Blackheath to Little Hartley tunnel EIS submission
Application number: SSI-22004371

Gary McCue
17 Thirroul Avenue
Blackheath NSW 2785

Figure 23-3 Construction GHG emissions by source

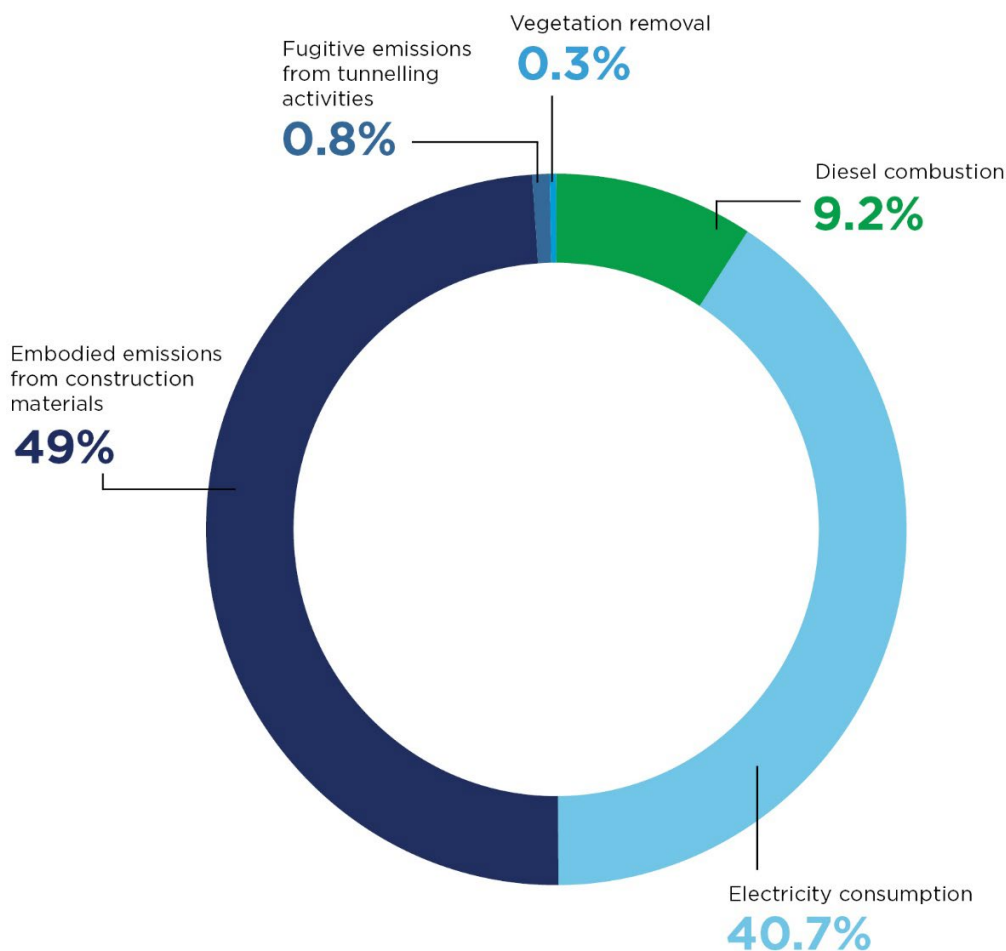
4) The lack of concern for Climate Change in this EIS, and the impacts this project will have upon our climate, is quite shocking. The EIS hardly mentions Climate Change throughout its 1000s of pages. Chapter 23 Sustainability, Climate Change and Green House Gases is one of the shortest chapters in the EIS, at just 17 pages, and there is basically no discussion of the impacts this road project will have on Climate Change due to encouraging more vehicles to use the GWH. Despite claims in the EIS that this tunnel project will reduce traffic due to allowing larger trucks, research has shown in the United States that building bigger roads doesn't relieve traffic congestion, it typically increases traffic problems. Sydney has discovered this every time roads like the M4 are widened; the result is more cars and trucks will use those roads.

Figure 4-12 Indicative vehicle cross-passage layout

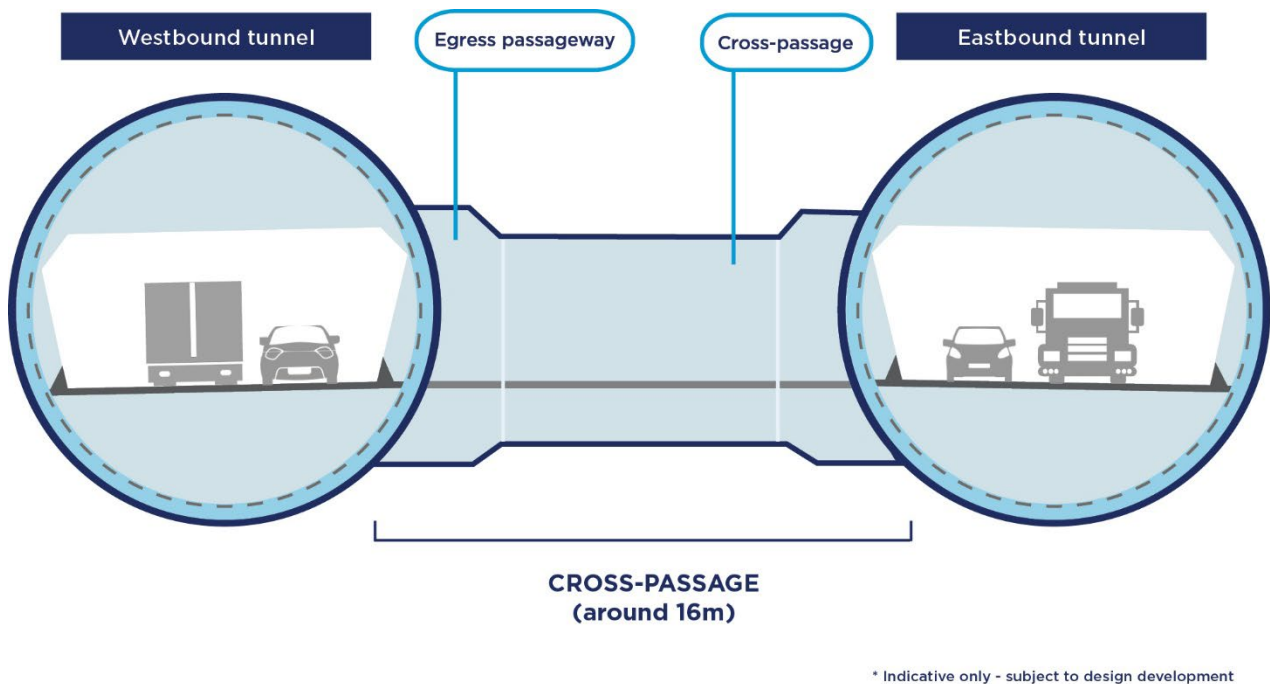
3) The impact on aquifers and groundwater from construction of the Blackheath tunnel is yet another major concern. According to the EIS, there will be cross tunnels approximately every 120m between the two main tunnels. Because these cross tunnels cannot be lined like the main tunnels, which are dug by TBMs, the digging of these cross tunnels using the Roadheaders will, according to the EIS, result in a maximum predicted tunnel groundwater inflow level that would peak at around 750 to 1,850 cubic metres per day (750,000 – 1,850,000L per day, 8.7 to 21.4 litres per second) associated with construction of the cross passages. This is 750,000 to 1.85 million litres PER DAY that will be entering the tunnel system, that will not be held in the many aquifers that are within the sandstone layers of the Upper Blue Mountains. Aquifers are the engine room of the many listed THPSS wetland ecosystems throughout the Blue Mountains, nourishing a wide range of flora and fauna, with several species endangered. The EIS goes on to explain that total inflows would be expected to decrease around 2029 once construction of these elements is complete. That's about a five-year period, if construction was to start in 2024. What if there is an extended

Figure 9-7 Buffer distances for Blackheath construction site

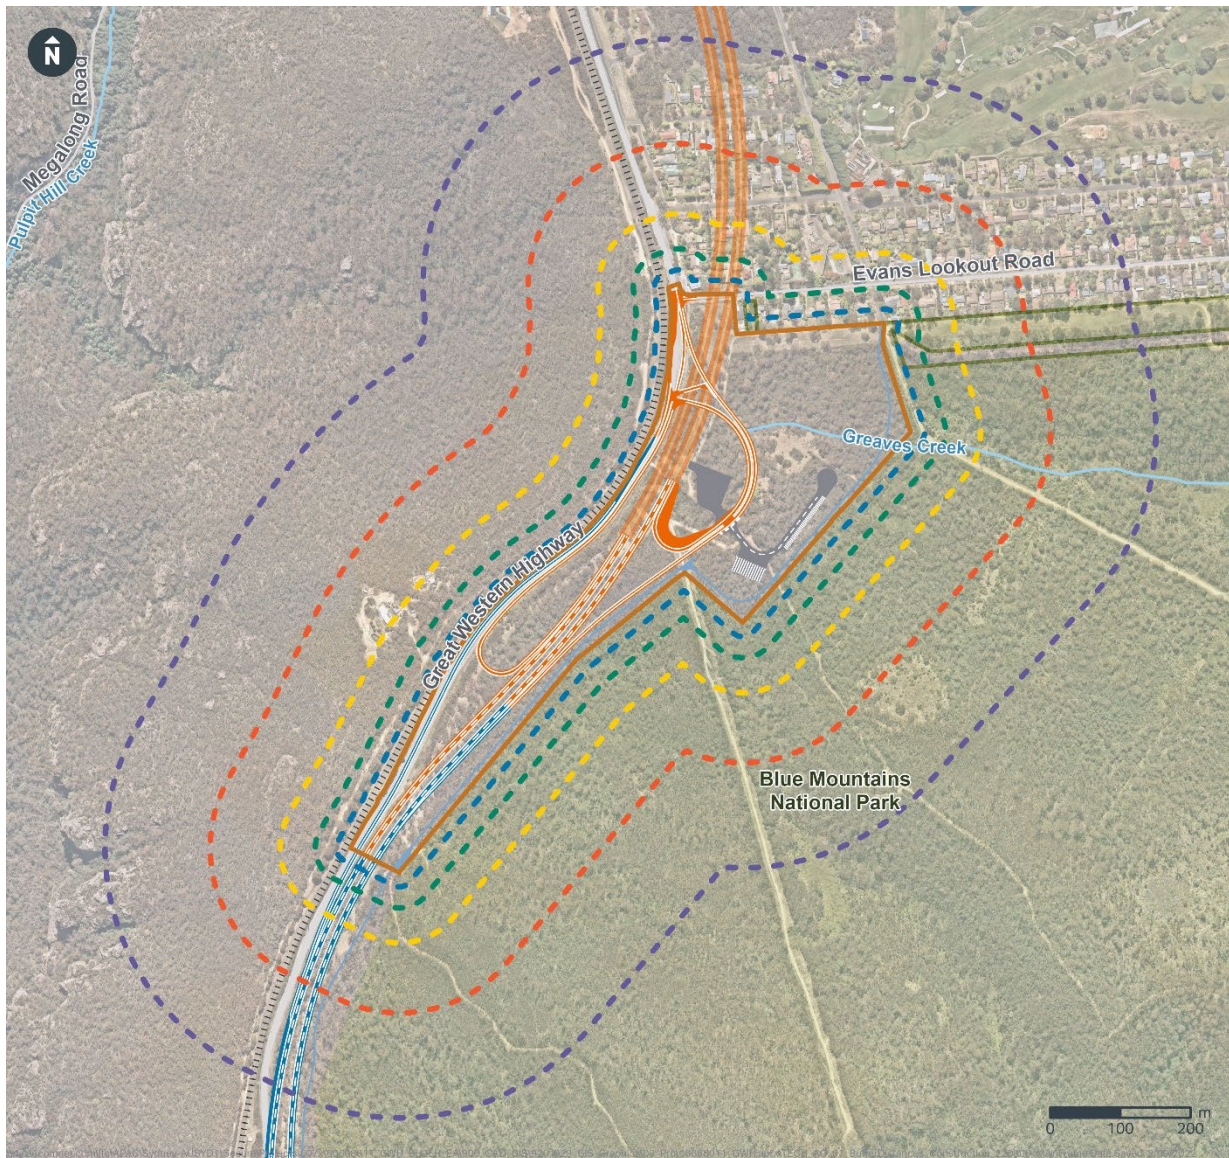
Also of concern regarding the Blackheath worksite and associated impacts upon the Greaves Creek catchment, is the choice by TfNSW to use just a 1500m radius buffer zone around this worksite for assessment purposes. I can see where the use of a 1500m radius buffer zone around tunnel worksites in the Sydney area is perfectly acceptable, but the Blackheath worksite is such a short distance from the boundary of the GBMWHA, and the many federally listed THPSS wetlands associated with the Greaves Creek drainage further downstream, which have known populations of endangered Giant dragonflies and Blue Mountains water skinks, but are inconveniently left out of this assessment due to being just outside of the assessment area, but close enough to be impacted by this major project. This too I find unacceptable within proximity to a WHA.

**Figure 1-5 Indicative construction footprint at Blackheath**

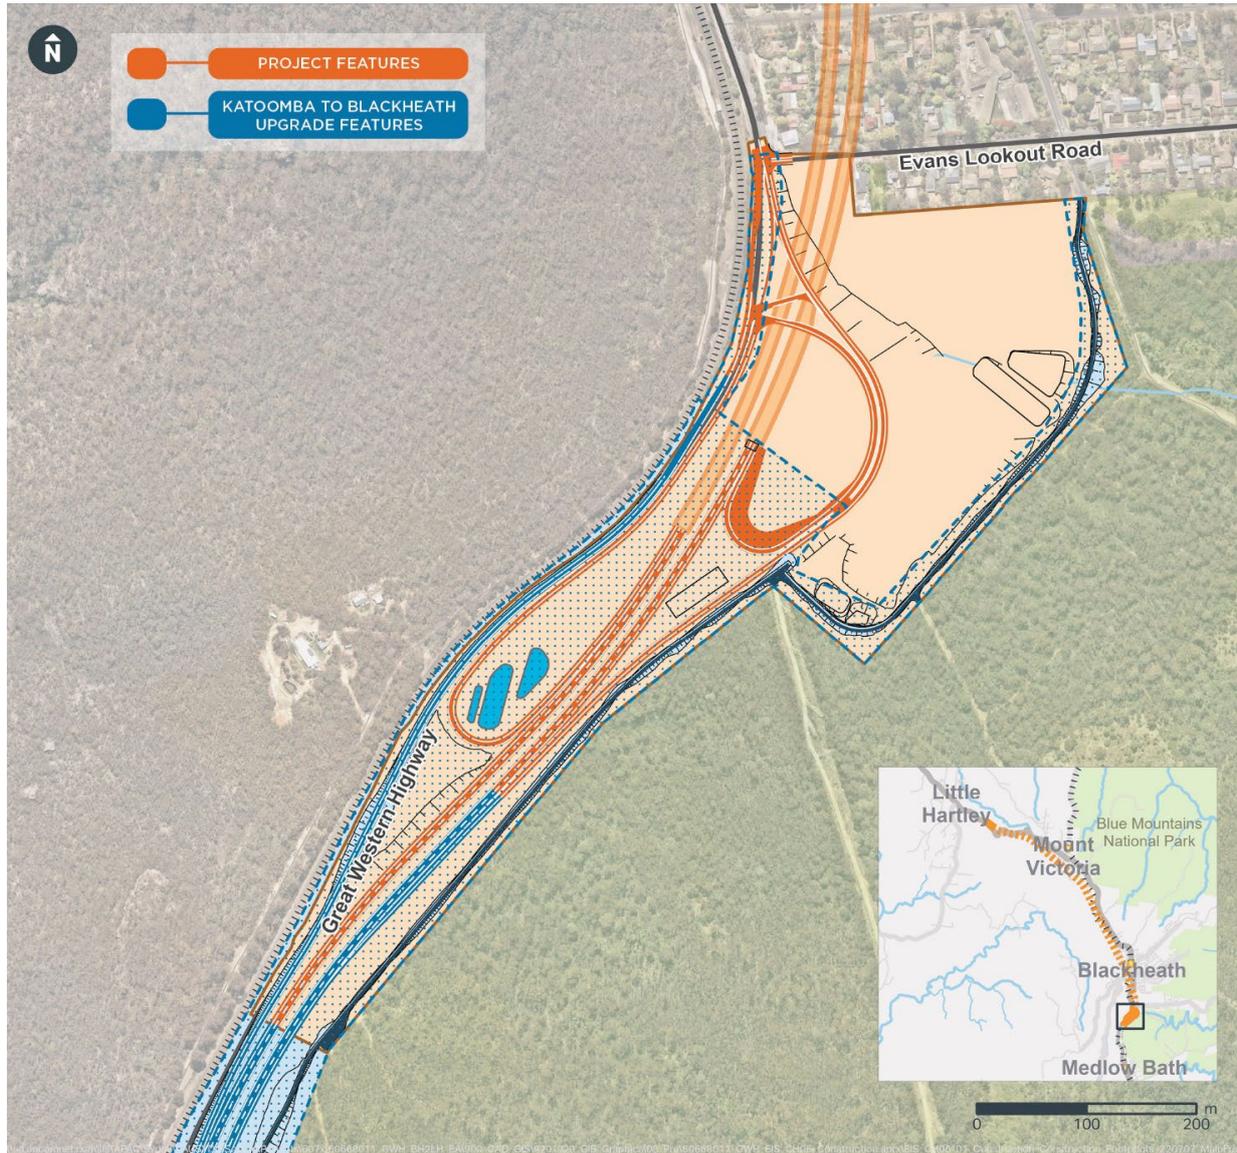
However the Katoomba to Blackheath Upgrade project REF has the Blackheath worksite not at the corner of Evans Lookout Rd and GWH, but back about 500-1000m at Tennyson Rd, back south along the GWH, and any assessments or approvals of this REF mentioned as a baseline for the EIS are only for the worksite at this location. It is only in the Submissions Report for the Katoomba to Blackheath Upgrade published after public comments on the original REF, in October 2022, that one finds the Blackheath worksite for this REF has been quietly moved to the corner of Evans Lookout Rd and GWH, with little or no environmental assessment (and no opportunity for public comment on these changes, so technically it never has been approved by anyone except TfNSW staff) despite now being located in the heart of the upper catchment of Greaves Creek, which is part of the Sydney Water Special Catchment area for our drinking water, which flows into Lake Greaves, and then on through to the GBMWA, through the iconic Grand Canyon hiking area to eventually reach the Grose River. Myself and others have looked through the chapters of this 233 pg Submissions Report and there is next to no information about the clearing of vegetation, or the management of weeds and sedimentation, or dealing with drainage issues as suggested multiple times in the EIS. What is mentioned and detailed in accompanying maps is the extension of the construction service road that will be used by construction vehicles and

emergency services traveling between Medlow Bath and Blackheath, so it connects with Valley View Rd between two unfortunate homes that will find themselves beside a new highway of huge construction vehicles, and the re-alignment of utilities such as fibre optic cables, but basically nothing about the environmental impacts of clearing this area of vegetation and transferring it into a major worksite. It is this sort of trickery and deception that can more easily be hidden when a big project like the GWH Upgrade is not under an all-project EIS, and is instead conveniently divided into 3 REFS and 1 EIS where there is little continuity and even less accountability in the environmental management of these four parts.

Also problematic with the Blackheath worksite is the proximity to at least 10 nearby homes, plus the neighbouring homes across the street and farther along Evans Lookout Rd and Valley View Rd. The back fences of these 10 homes will go from being an ideal garden setting with undeveloped national park and forest and animals, to a denuded hell realm of dust and noise and vibrations and lights and machinery, and hundreds of vehicle movements per day, 24/7 with the digging of the cut and cover tunnel portals to align with where the TBMs finish. Why can't TfNSW give these poor souls a break and move the worksite back south a few hundred metres, as well as creating a barrier between the worksite and the back yards of these homes? What if you lived there? When I asked Alistair Lunn about what mitigation would be offered these home owners, he told me the usual offer was double glaze glass and air conditioning. This construction site will be here 9+ years, first with the Katoomba to Blackheath Upgrade, followed by the tunnel construction, and finishing with the building of permanent infrastructure that will accommodate tunnel personnel, emergency workers, water treatment, etc. Can you actually think that families can survive being locked in their homes for all those years behind double glazed windows, air conditioning on (in summer only), their children unable to play in the back garden because it is choked in dust?

Another issue with the Blackheath worksite is the plan to store up to 5000 cubic metres of tunnel portal spoils, uncovered. But the Little Hartley worksite, with a spoil pile of up to 20,000 cubic metres, will be enclosed in an acoustic shed to reduce noise and minimize drainage issues from weather events. Yet only a few residences are near the Little Hartley site, compared to the Blackheath site. Are the folks in Little Hartley considerably more noisy about their situation and have therefore been placated with promises of an acoustic shed? Surely the homes adjacent to the Blackheath worksite deserve an acoustic shed? And with this worksite situated right in the headwaters of Greaves Creek, it seems a no-brainer to be covering this spoils pile to prevent drainage and sedimentation issues if we have large rainfall events of hundreds of millimetres in a day or two as has happened several times in the past few years.

And then there is the issue of parking. A 100-car parking lot is mentioned in the EIS, as is the potential for workers to use on-street parking along Evans Lookout Rd. during the day and at shift-changes. Has TfNSW actually looked at the potential for parking cars along Evans Lookout Rd? There isn't much room due to the residents' gardens, therefore a better plan is needed to reduce the impact on these residents who have the unfortunate situation of having your worksite moved to butt up against their back fences.
